From: Planning
Subject: FW: Objection to planning application 03/2020/1015 Inglemead, Waddington Road, Clitheroe. BB7 2HN.

We wish to object to planning application **03/2020/1015**, Inglemead, Waddington Road, Clitheroe, BB7 2HN.

Drawing No. A200 Revision

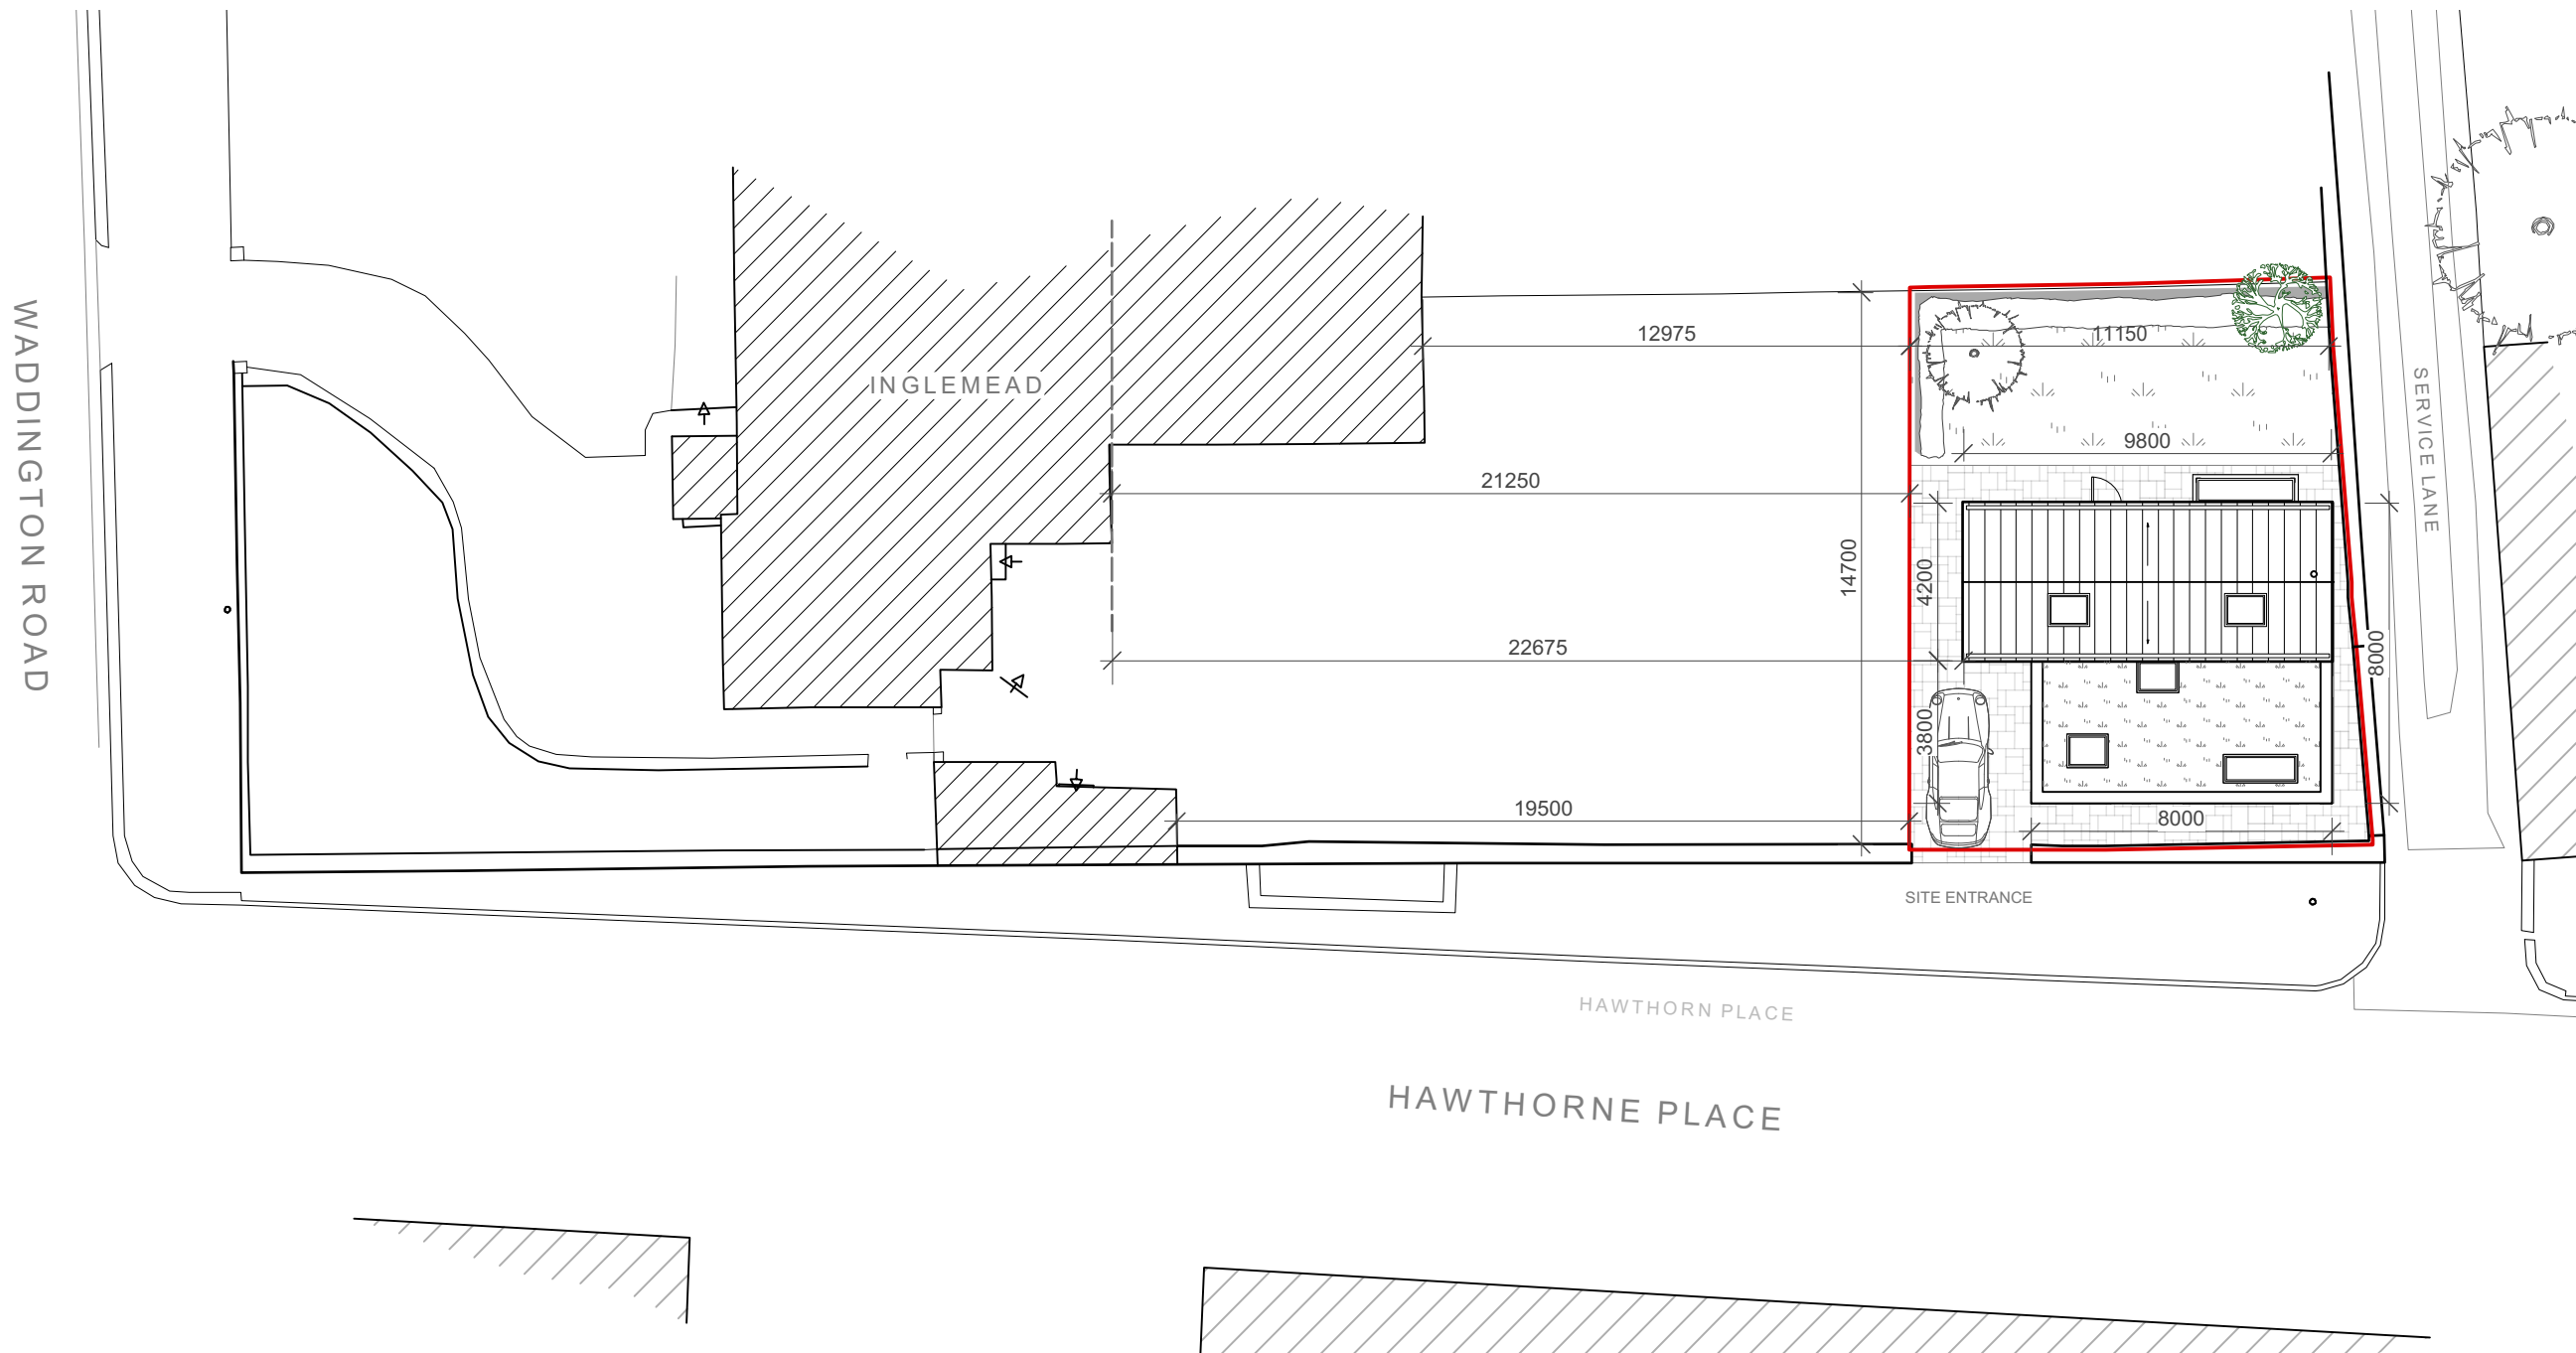
The reason for this objection is primarily on highway grounds and the access onto Hawthorne Place. This road is already congested, the terraced properties close to this proposed development have no off street parking and are forced to double park along the street.

Although this property has one off street parking space, a parking space is lost on Hawthorne Place in order to access this space. As the occupants of this two bedroomed property are highly likely to have more than one vehicle which will then be street parked, this will cause the loss of two spaces for the current residents and this is wholly unfair.

LCC Highways rightly state the high walls at the driveway of this proposed property are a danger to road users and pedestrians. However to lose this old and visually pleasing wall that is typical of the area would be unacceptable to the residents here. There is already an existing entrance to Inglemead onto the service street, if this continued to be the access point, there would be less loss of parking to existing residents. The danger due lack of sight and visual amenity would remain as it stands at present and privacy would be maintained to the properties opposite.

Drawing No. A200 Revision A

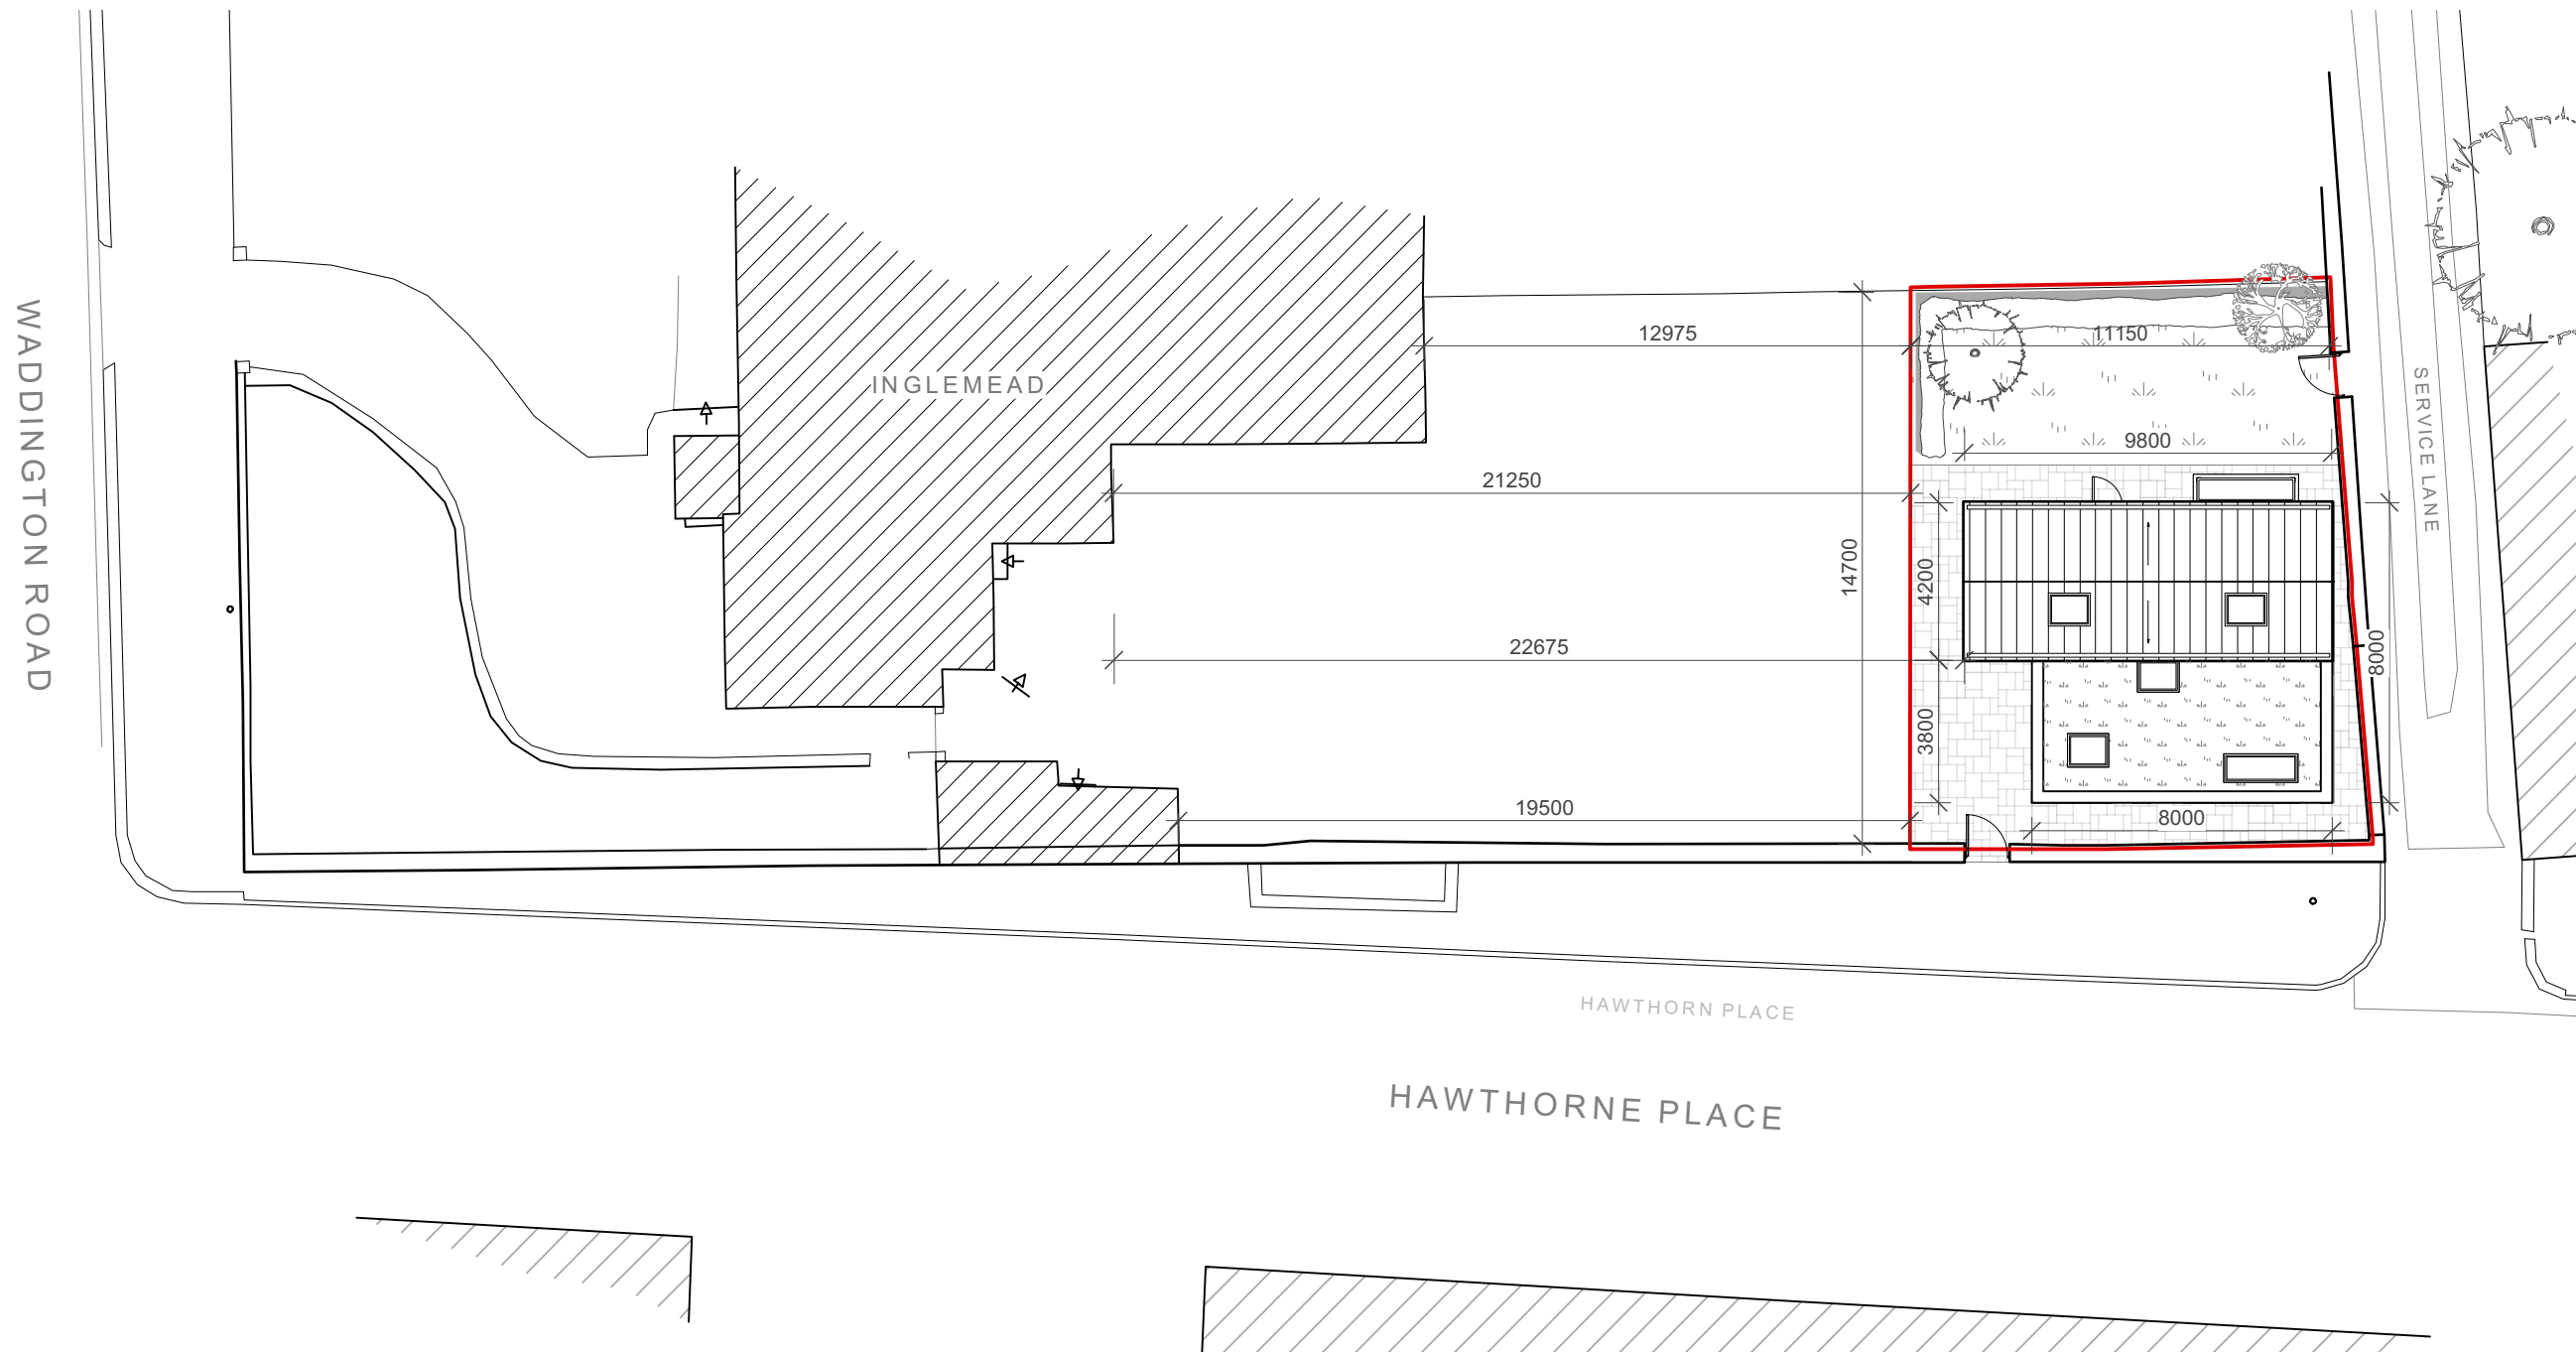
We spoke today in relation to the above application and you clarified that the amendment was now no provision for off street parking at all. I now wish to further **object** as this amendment makes the application even more unacceptable, may I also further reiterate the objections contained in the attached email sent to you on 22/12/20.

The fact that amenities are within a walkable distance from this property does not in any way mean that the occupants will not require a vehicle and are more than likely to have two. Parking is already at a premium here, it is not at all fair that existing residents should have to contend with even more competition for parking when provision could be made on this site. By not insisting that parking is provided where the conditions here are already congested will cause a negative impact on our residential amenity. By using the existing access it would cause less of a problem.
